HERTFORDSHIRE BIOLOGICAL RECORDS CENTRE

Planning Ref: S6/2012/0719/MA; 17-23 Church Street and car park adjacent to George's Gate entrance HATFIELD AL9 5AS. Demolition of 17-23 Church Street and garages. Erection of 7 x two bed houses, 1 x two bed flat and 2 x one bed flat on 17-23 Church Street with associated parking and landscaping; 1 x three bed house and 1 x one bed flat on car park adjacent Georges Gate and 38 car parking spaces and associated landscaping.

Re: Bat Survey and Mitigation report, Maydencroft Land Advisory. October 2011.

Appendix B. Proposed Development with Bat Mitigation Locations | Church Lane

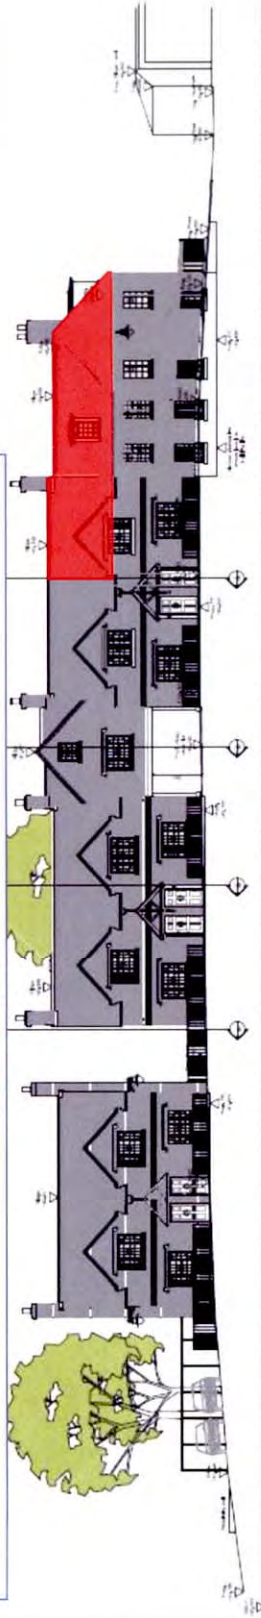
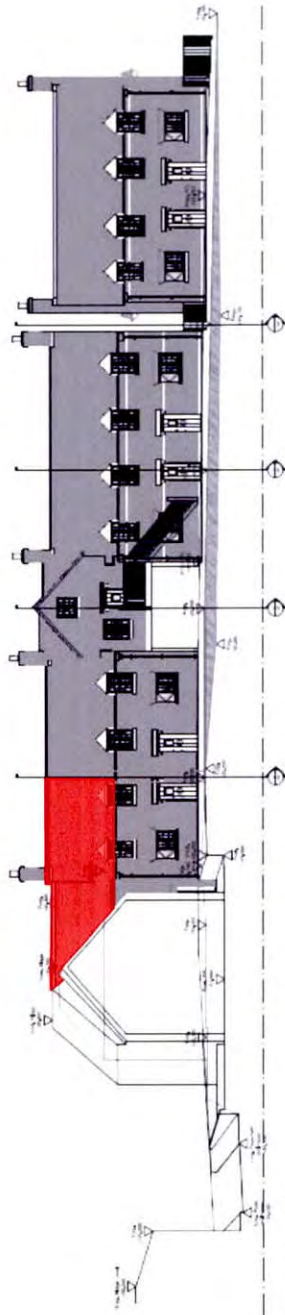
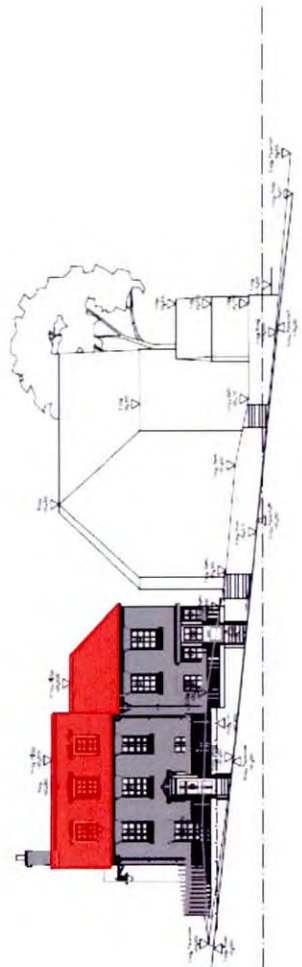
- In the event of bats being found, they will be removed by the bat ecologist to a safe location.
- Suitable access points and alternative roost sites should be incorporated into the new build (See Appendix B and C.). At least one ventilation ridge tile should be modified to allow access into the ridge. Other features such as using bitumastic roofing felt and suitably sited low safety lighting are discussed.

- Demolition will take place during the period November-March inclusive, in the presence of a licensed bat ecologist.
- A European Protected Species license will be obtained before demolition starts.
- A licensed bat ecologist will be present when the roof tiles and covered cavity walls are removed.
- In the event of bats being found, they will be removed by the bat ecologist to a safe location.
- Suitable access points and alternative roost sites will be incorporated into the new dwelling. Type, design and location will be determined by a bat ecologist.
